William Parker
554 McNeill Mill Rd.
Broadway, NC 27505
Re: Parker's Pizza

The plans for this facility have been reviewed and are approved with the following conditions:

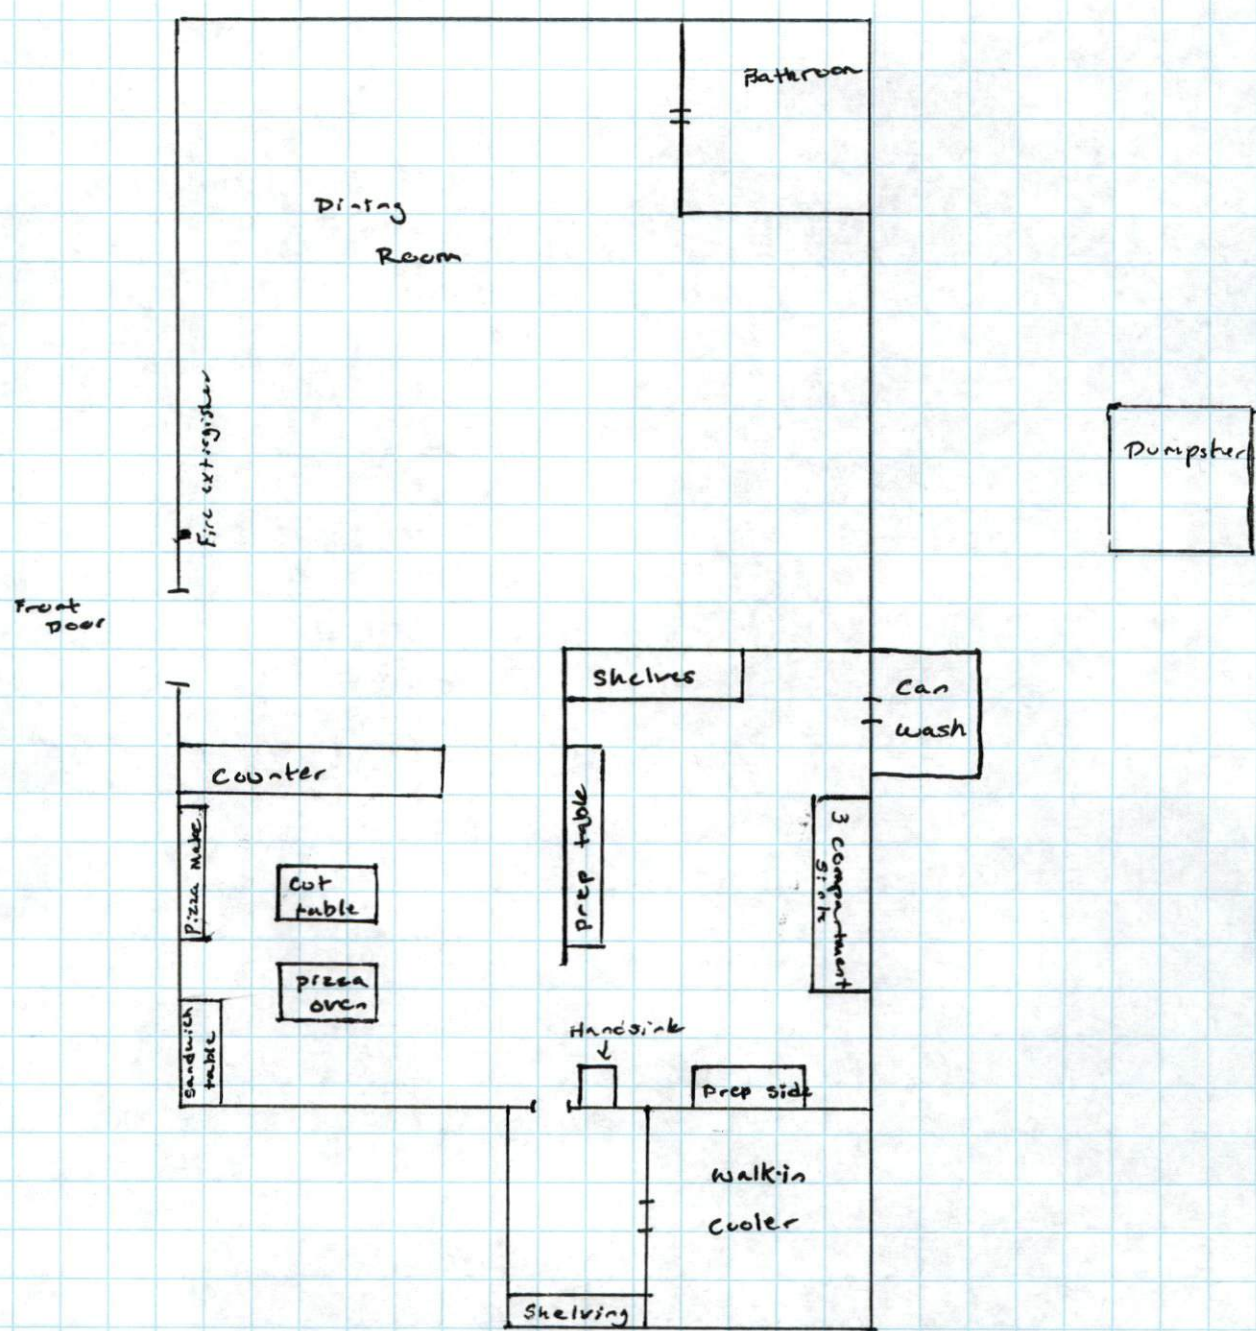
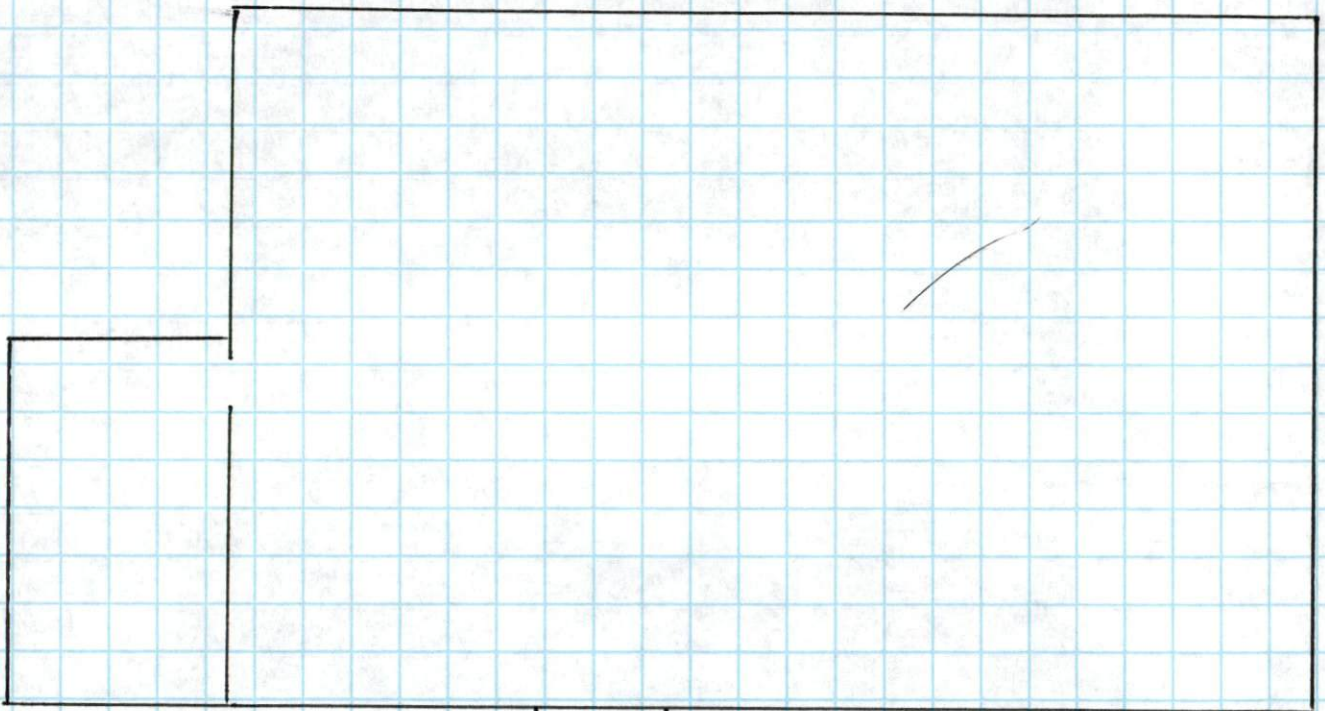
6-The dumpster shall be stored on a nonabsorbent surface, and must be a concrete dumpster pad shall be provided or ensure the dumpster is stored on a surface of nonabsorbent material, such as concrete or asphalt.
